A38 Derby Junctions
TR010022

**8.103 Applicant's Responses to Information
or Submissions Received by Deadline 12**

Regulation Number	Rule 8(1)(k)
Planning Inspectorate Scheme Reference	TR010022
Document Reference	TR010022/APP/8.103
Author	A38 Derby Junctions Project Team, Highways England

Version	Date	Status of Version
01	19 May 2020	Deadline 13 Submission

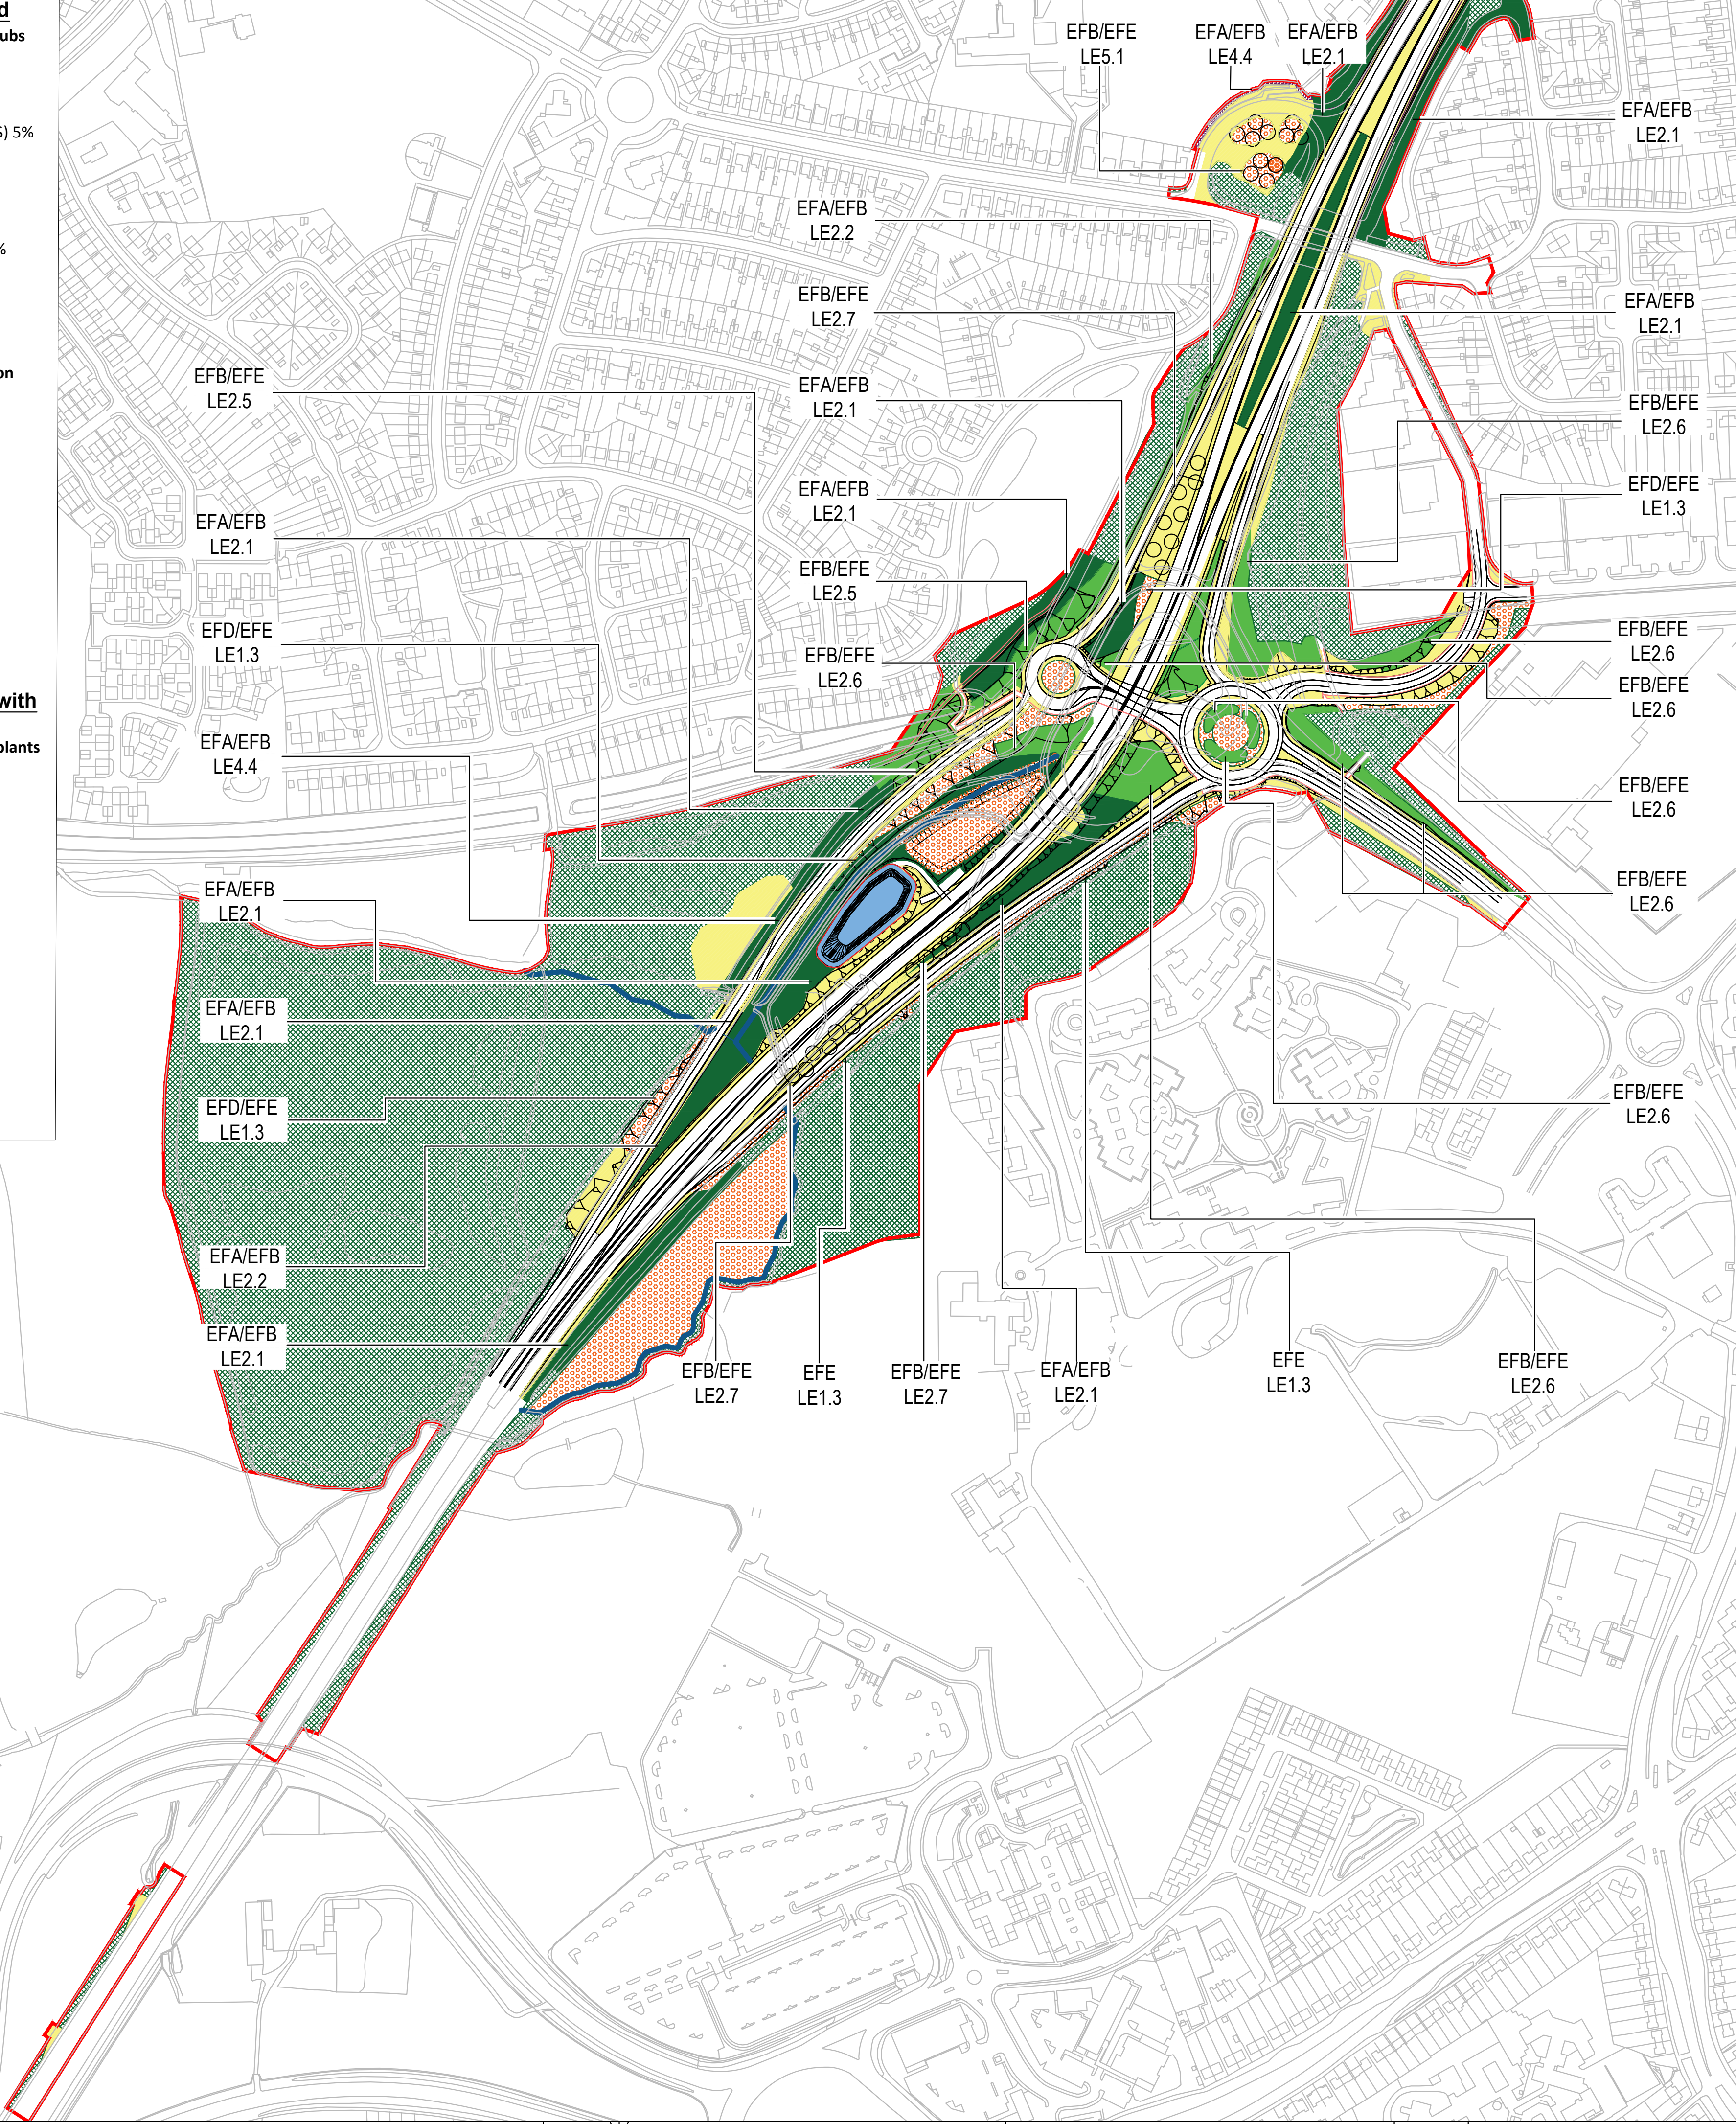
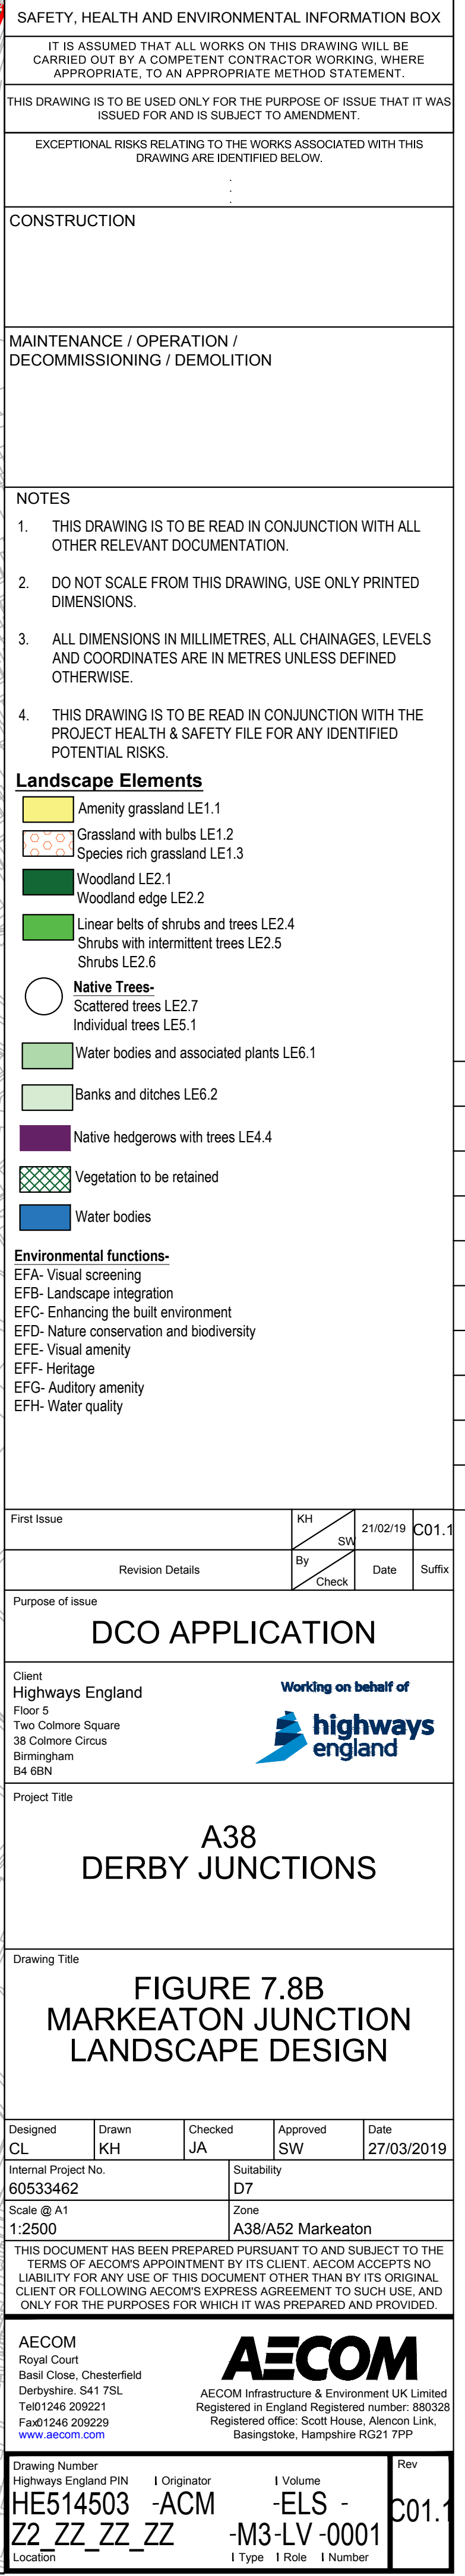
Ref	Comment	Applicant's Response
	<p>ecologists who carried out the Phase 1 Habitat surveys with the unrealistic maps in Environment Statements now.</p>	<p>these properties is detailed in the Statement of Reasons [REP9-005].</p> <p>With regard to the comment that FOMP do not consider that the loss of those irreplaceable trees (from the tree belt) could be mitigated, including impacts upon veteran tree DWT no. 26. As detailed above, veteran tree DWT no. 26 is located within Markeaton Park beyond the Scheme boundary and will be unaffected by the Scheme – thus no mitigation for this tree has been provide. With regard to Scheme impacts upon veteran tree T358 located adjacent to the existing footbridge near Mill Pond – if this tree is lost, it is agreed the loss of such a veteran tree cannot be mitigated. This is why during the detailed design stage Highways England will investigate whether the veteran tree can be retained and the Scheme's impacts upon the tree's Root Protection Area (RPA) reduced (refer to Highways England document [REP7-008], plus provisions in the OEMP [REP12-002]). The loss of the other trees from the tree belt will be mitigated via replacement tree planting – noting that Highways England will deliver a landscape design that results in a net increase in the number of trees in Markeaton park – this commitment is confirmed in the OEMP [REP12-002]. It is also noted that a number of semi-mature trees will be planted in prominent locations around the Scheme (detailed as plot type LE5.1 – individual trees on the landscape design drawings shown in Figures 7.8a to 7.8c [APP-094]) – this includes along the edge of</p>

Ref	Comment	Applicant's Response
		<p>Markeaton Park. It is also noted that as confirmed in the OEMP [REP12-002], the landscape planting proposals for Markeaton Park will be defined in consultation with the park owners, DCiC.</p> <p>It is unclear what mitigation proposals FOMP are referring to that were "<i>promised around 2015</i>". Regardless, the mitigation proposals as included in the Scheme design detailed in the Environmental Masterplan figures (ES Figure 2.12C/ D [APP-068]) takes account of Scheme design evolutions since 2015 and the findings of environmental surveys undertaken to support the environmental impact assessment as reported in the ES. It is noted that the AECOM ecology team has been providing ecology survey and mitigation design inputs to the Scheme since 2014. Thus Highways England disagree that there are "<i>unrealistic maps</i>" in the ES.</p>
<p>Question 9.1 Special Category Land The Markeaton Park 'Mundy covenant</p>	<p>In 2003 the covenant guardian's father was alive. Then he would have supported the principle of grade separation. Trustees who attended the 2015 consultation believed the assurances that mitigation would make-up for losses. The current holder does not live in Derby but acts regularly, upholding the responsibility of the restrictions and covenant. Friends of Markeaton park respect her diligence. The information that is sent from Derby is unlikely to include the detailed scrutiny the Examining Panel has instigated. Information is dispersed over thousands of pages and dozens of maps; it is extremely difficult to</p>	<p>It is not clear what relevance these comments regarding the Mundy covenant have to the Scheme, although they are noted.</p> <p>With regard to the comment "<i>will the "net gain" for Markeaton Park be one extra sapling</i>". Highways England will deliver a landscape design that results in a net increase in the number of trees in Markeaton Park – this commitment is confirmed in the OEMP [REP12-002]. The landscape planting proposals for Markeaton Park will be defined during the detailed design stage as based upon ES Figures 7.8A-C [APP-094]. As such it is not currently possible to</p>
